Your Reference	SSD 9670
Our Reference	NCA/3/2019
Contact	Luca Chudleigh
Telephone	9806 5600
Email	LChudleigh@cityofparramatta.nsw.gov.au

28/06/2019

**RE: WESTERN SYDNEY UNIVERSITY INNOVATION HUB (SSD 9670) – 2-6
Hassall St, Parramatta**

DRAWING NO.  
6HS-ASP-L01.03  
D

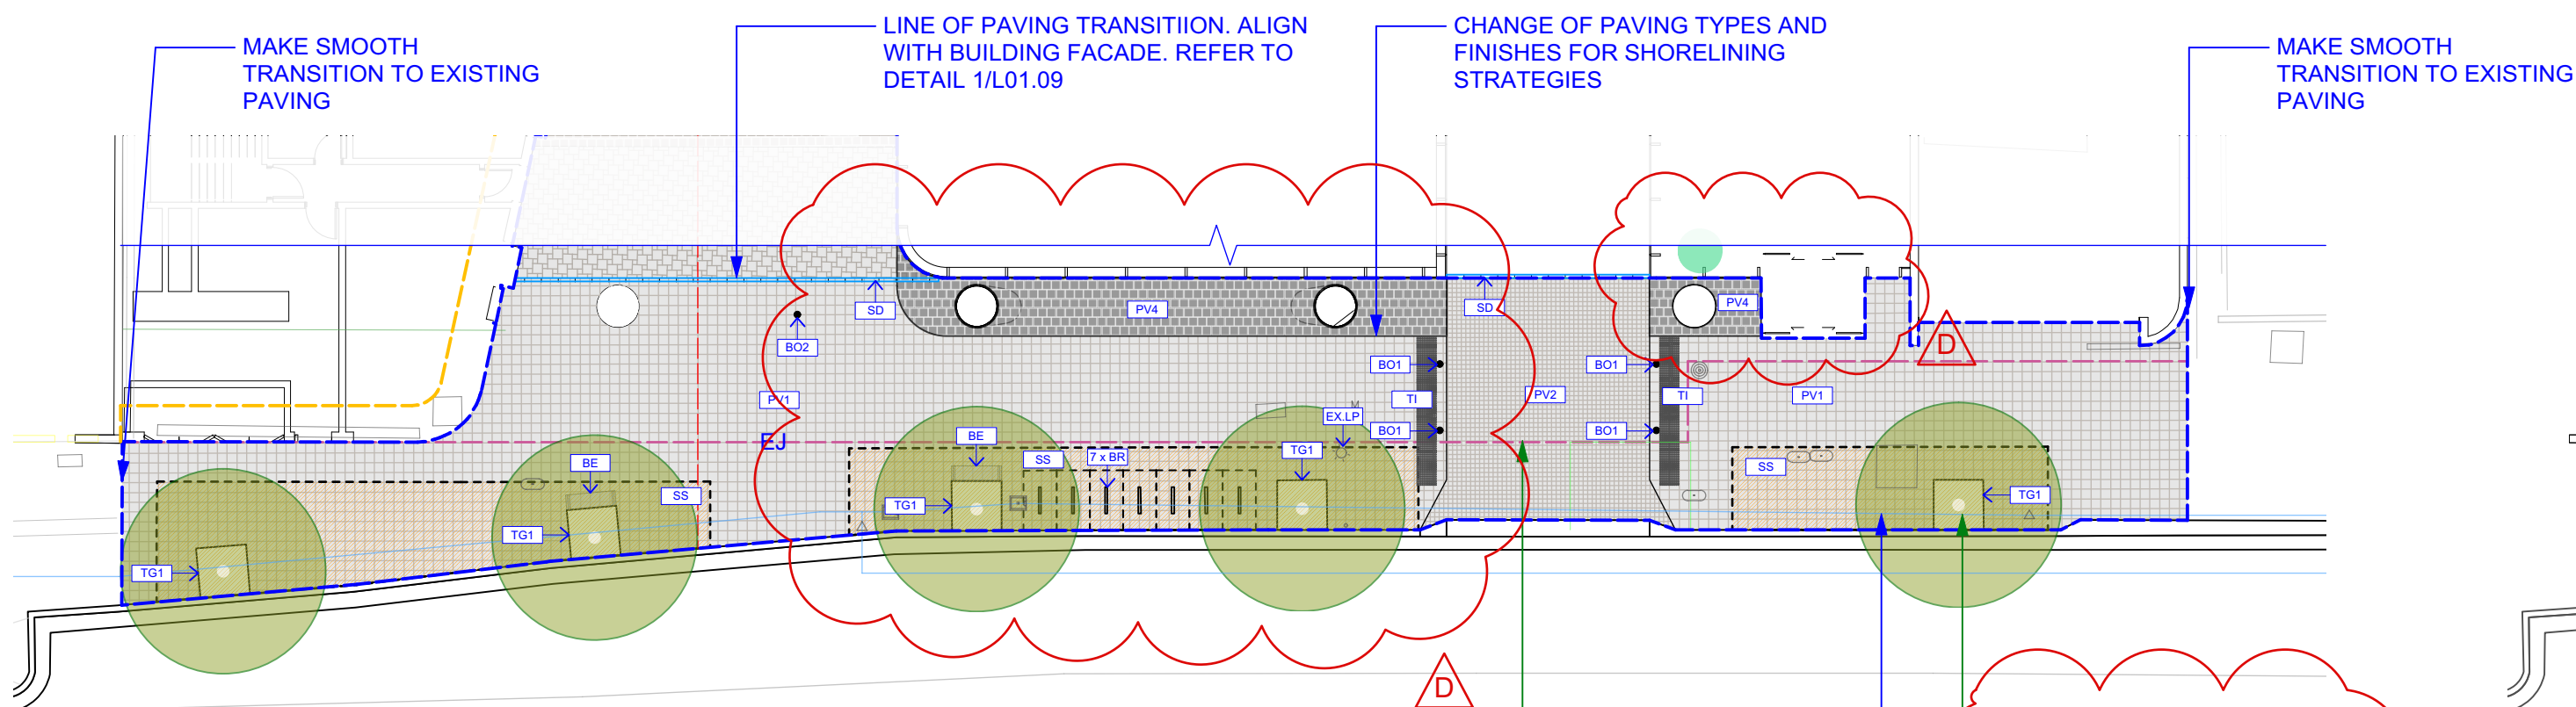
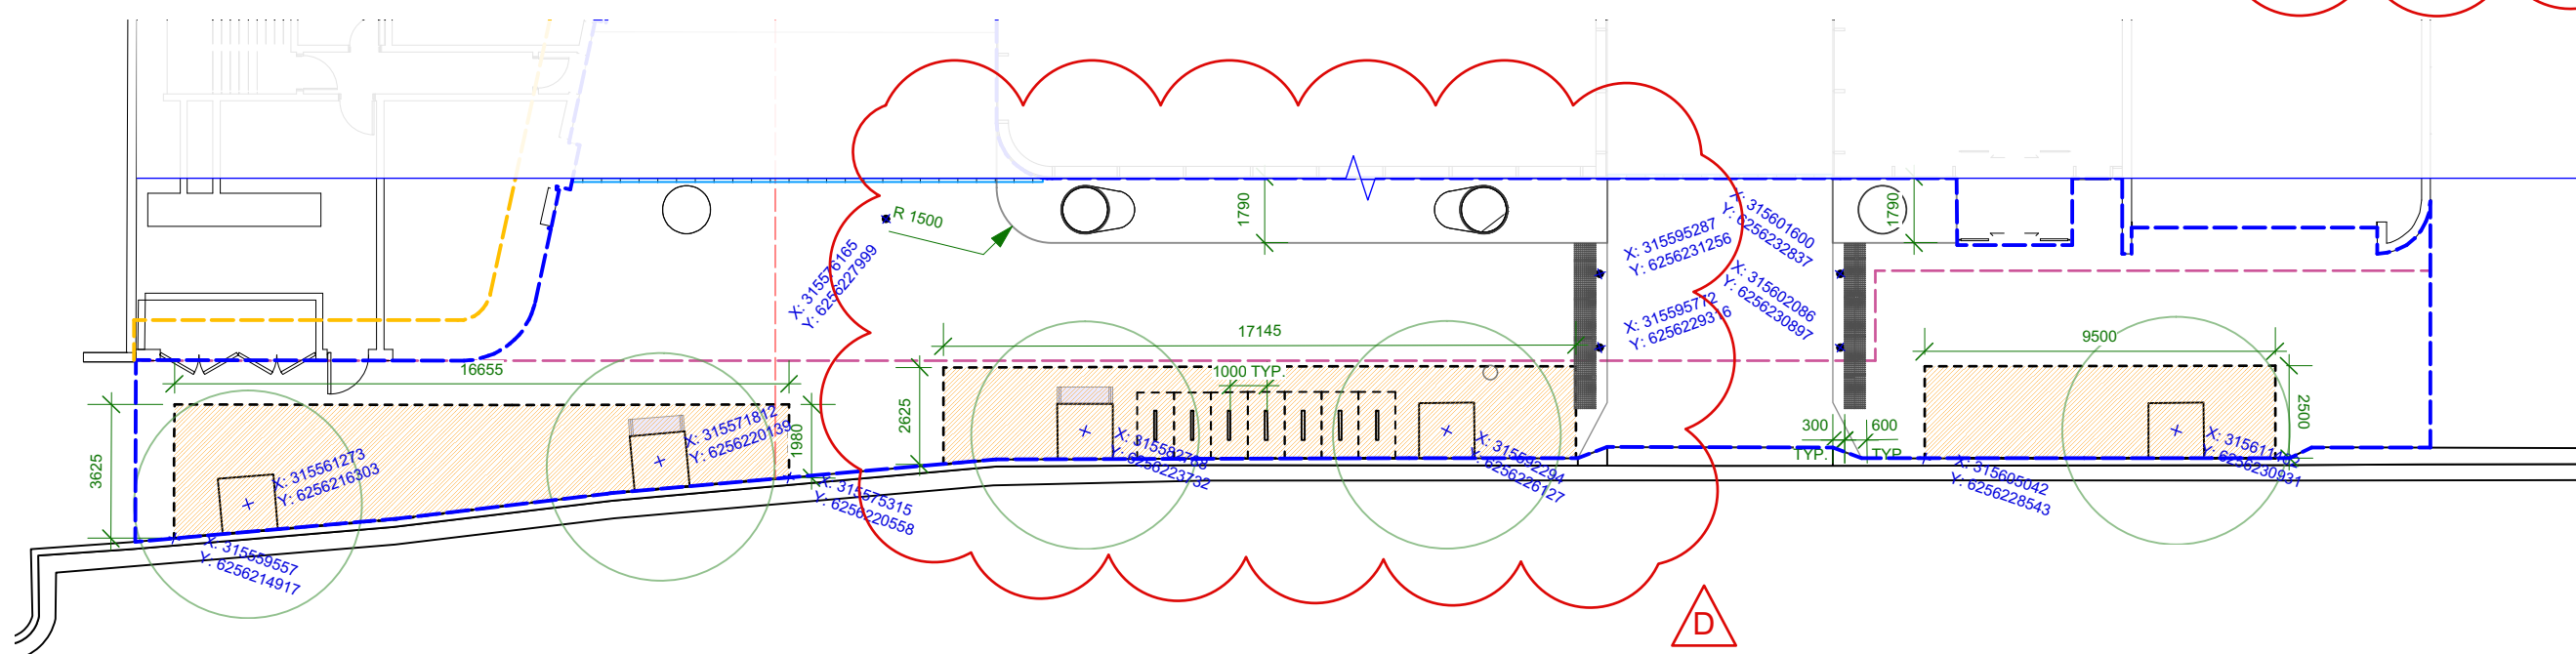
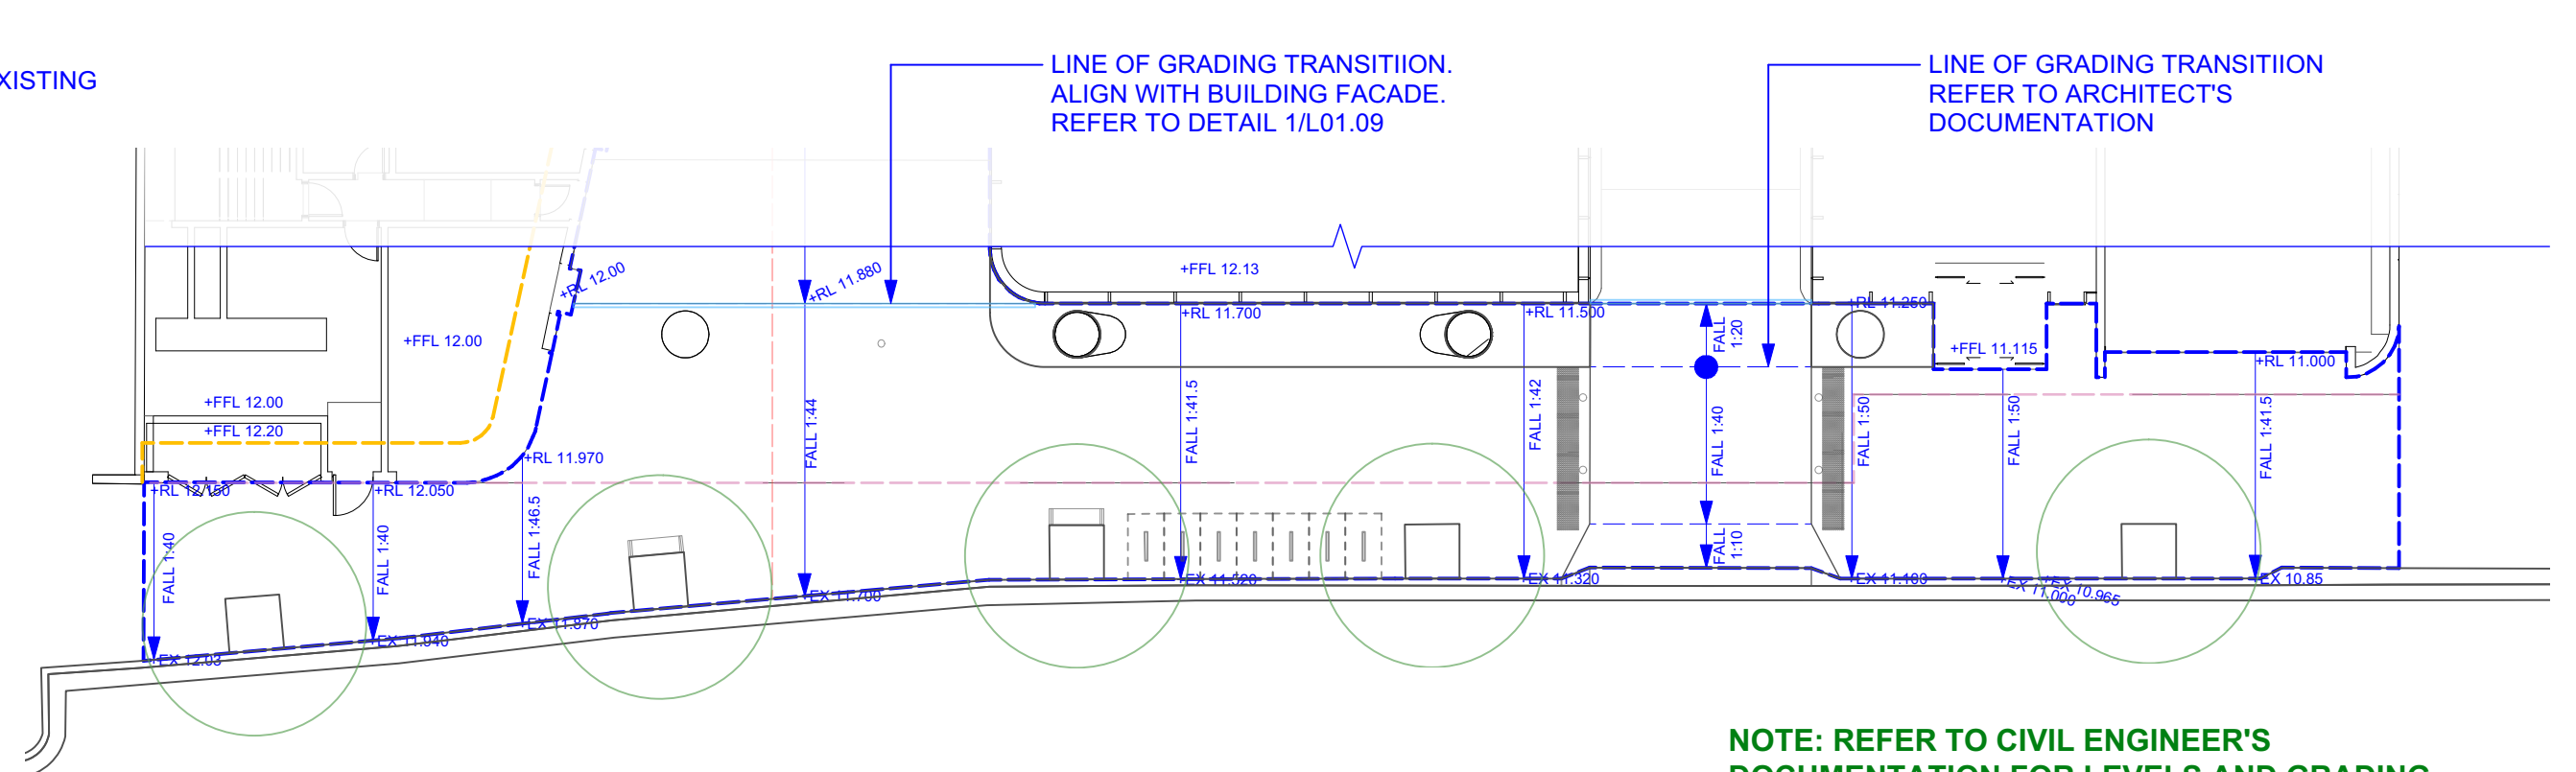
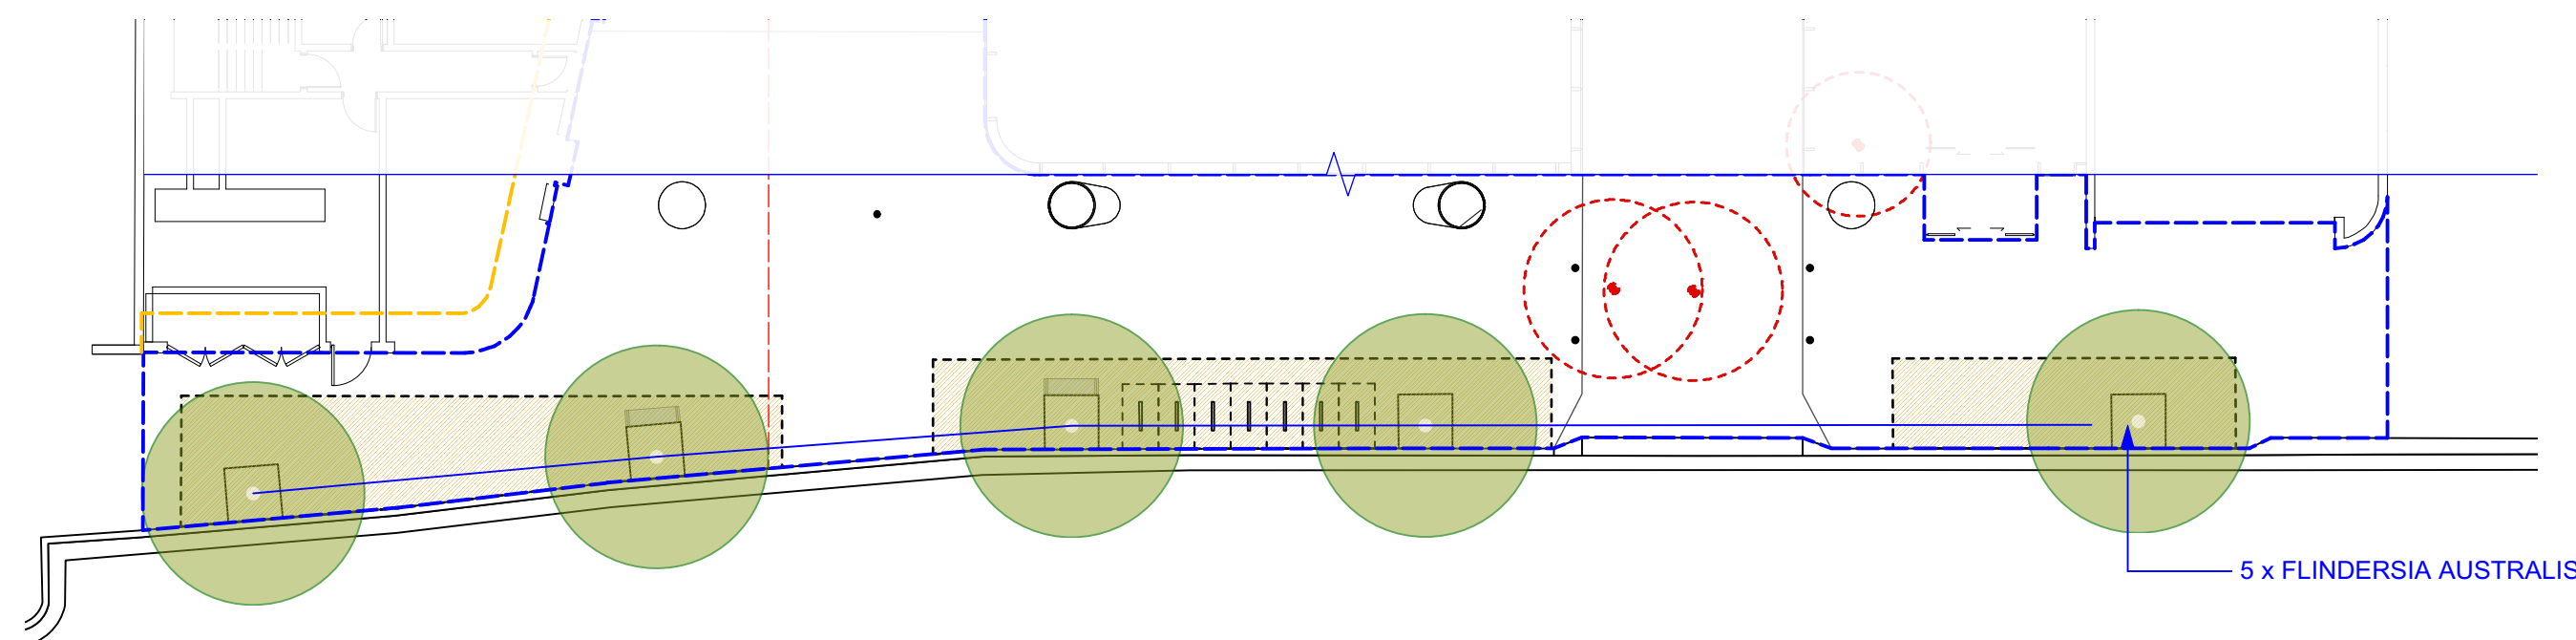
- Demonstration of how the future through-site link will work. This needs to be demonstrated with design options and levels.
- The Hassall St façade presents little activation of the public domain with the presence of a lab, a driveway and a substation. The applicant should consider a redesign to present better activation.

- Building columns along the footpath on Hassall St are not encouraged since they disturb a continuous line of travel and fail to provide a consistent shoreline. The applicant is required to provide a legible shoreline along the public domain along Hassall Street. The shoreline does not need to be a continuous line of TGSIs. The applicant is encouraged to explore and present textures in paving, while keeping the material consistent, to enable detection. Shore-lining principles should follow AS 1428.

- Ensure the bicycle stands sit outside the shoreline.
- The public domain through the future through-site link requires a shoreline to ensure all pedestrians are able to traverse through it.

- The bollards shown at the driveway crossover of Hassall street footpath are not recommended. These should be replaced with warning TGSIs.
- Street tree soil volumes and planting details should be as per the Parramatta Public Domain Guidelines 2017.

- Street lighting seems to be missing from the public domain plan.
- Explore relocating the substation to next to the retail at the boundary with the Commercial Hotel or in another area. Any required vehicular access to the substation needs to be demonstrated.

- Ensure slabs within apparent public domain are separate along the property boundary and that the property line is demarcated within the public domain in some manner.

- Ensure water positively drains away from the building edge and property line. Detailed levels are required to demonstrate this.

Sheet Name
BASEMENT
©BLIGHT RAYNER ARCHITECTURE PTY LTD ACN 614335956
Use figured dimensions only. Do not scale. Check all dimensions on site prior to fabrication or setout. These designs, drawings and specifications are copyright and must not be used, kept or copied by any means without permission.

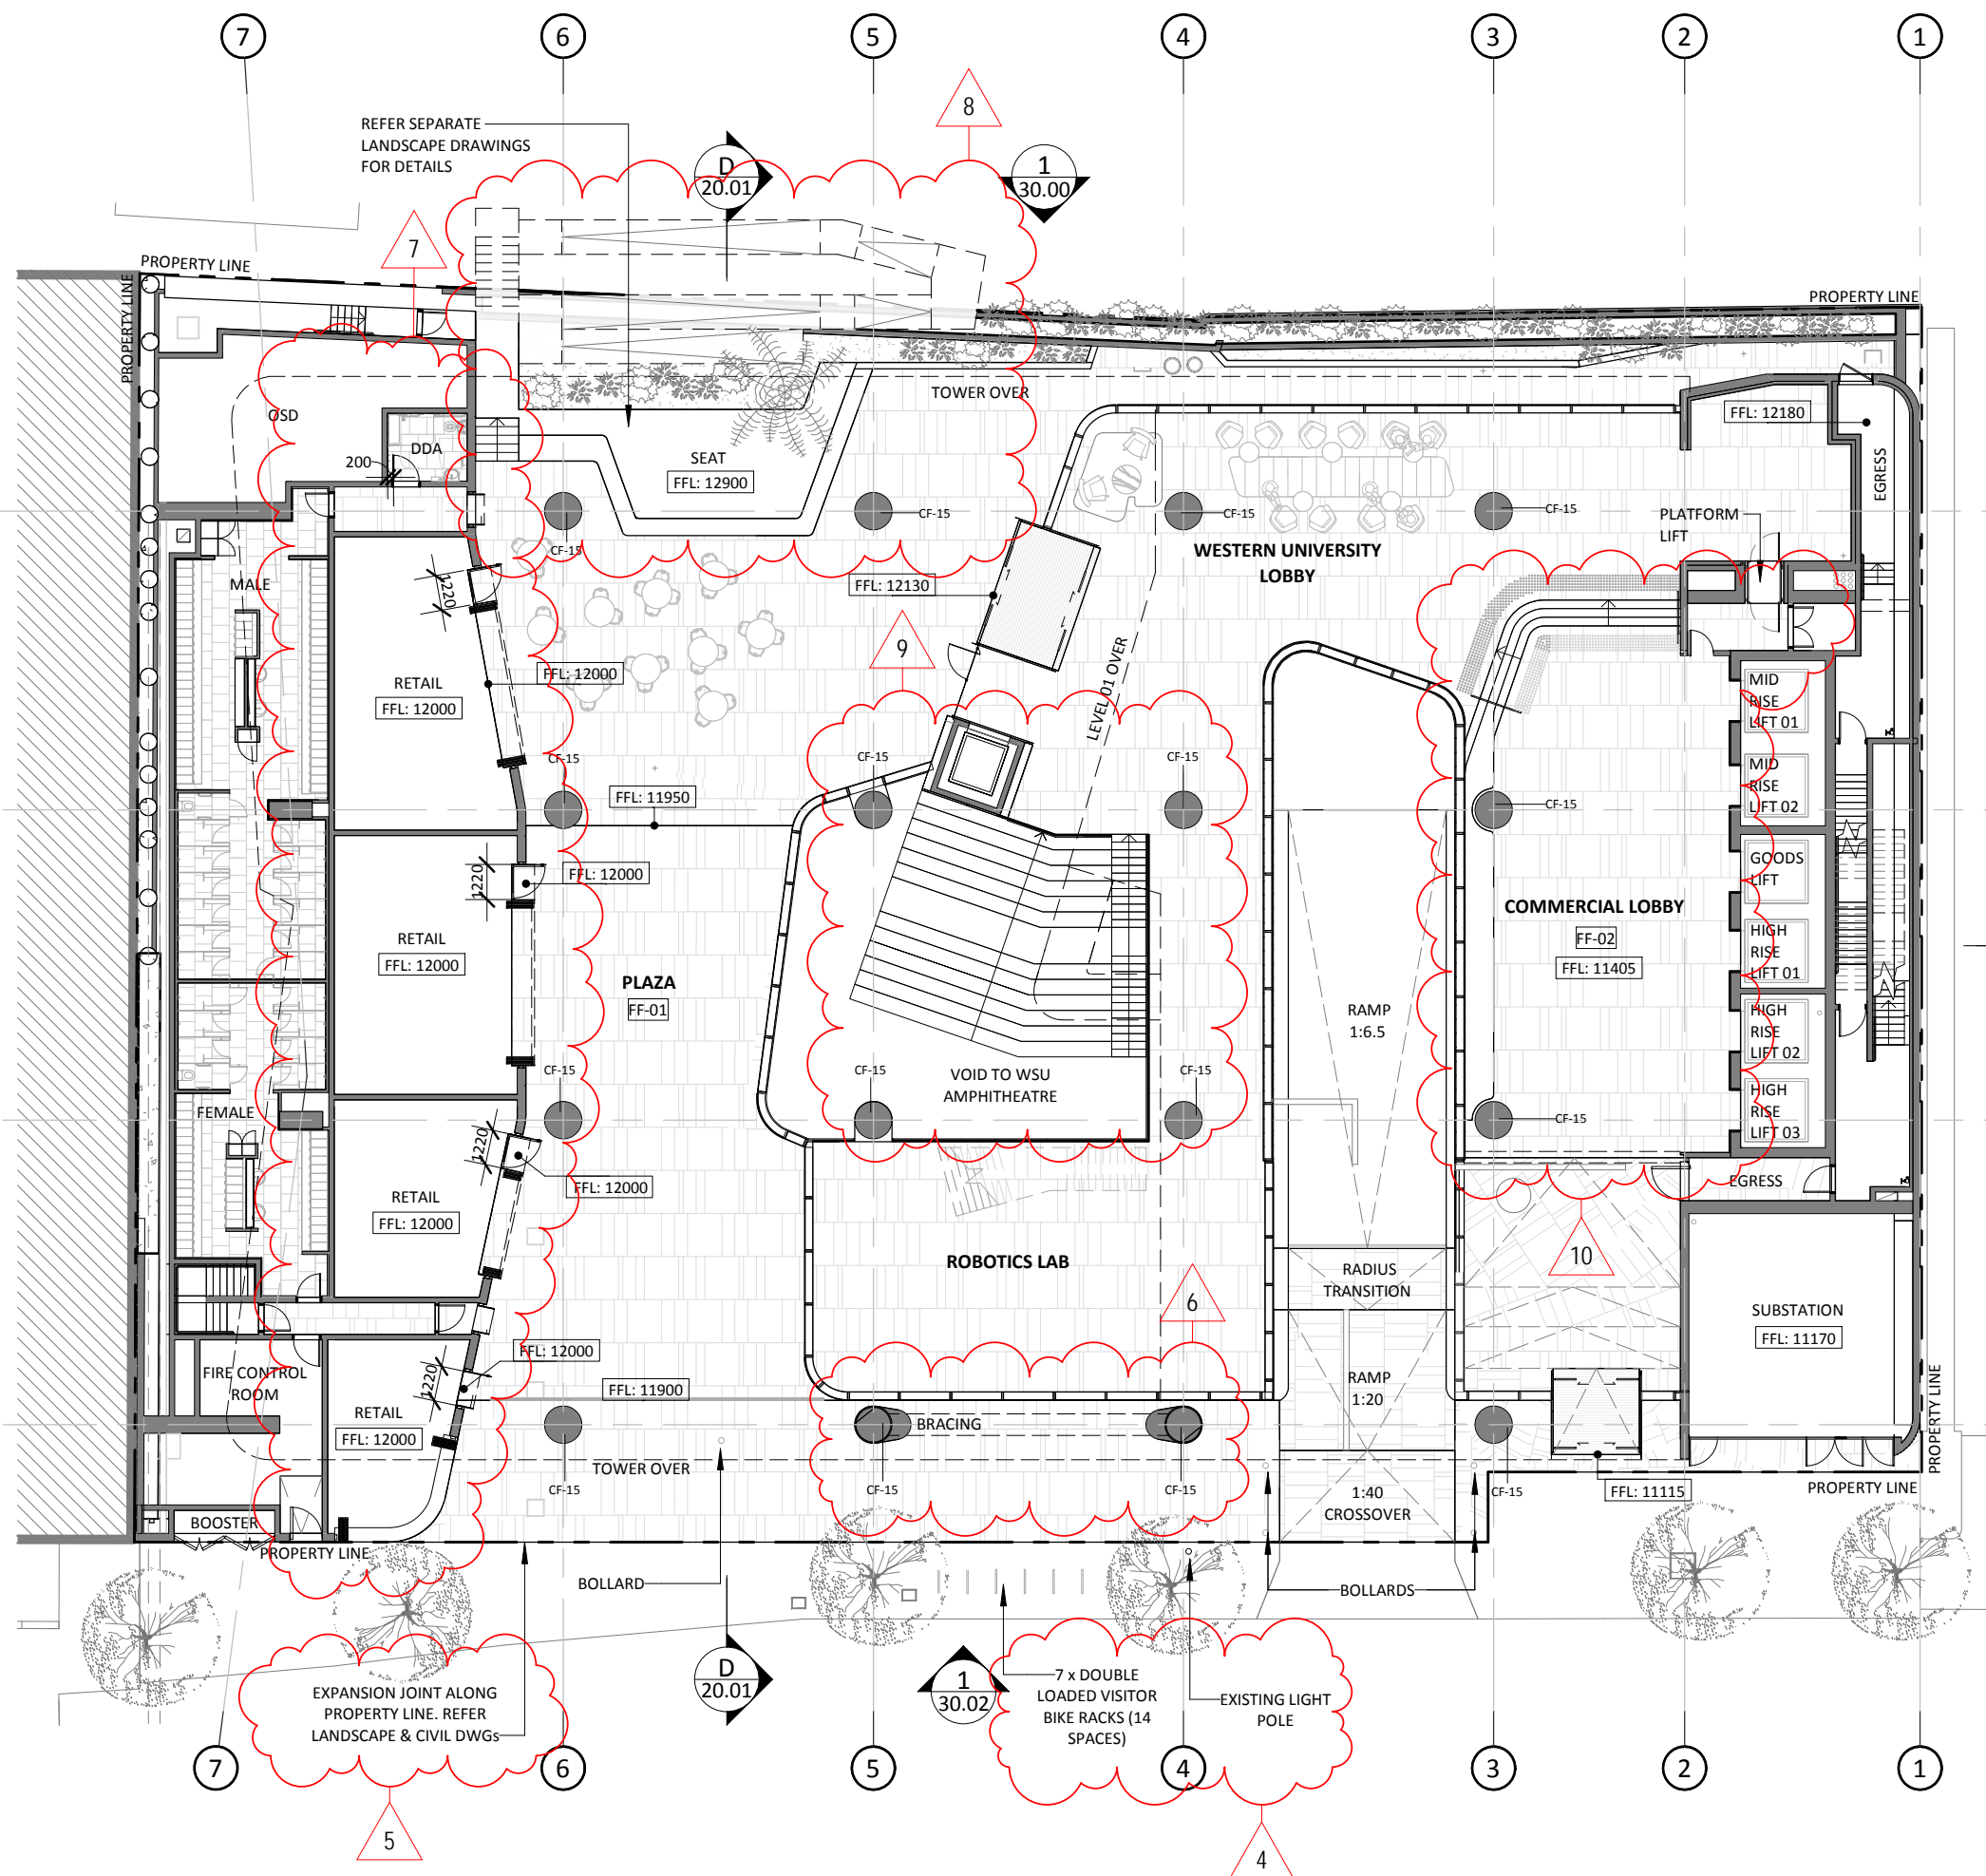
- Must ensure that adequate sight distance in accordance with AS2890.1-2004 is achieved at the basement entry driveway.
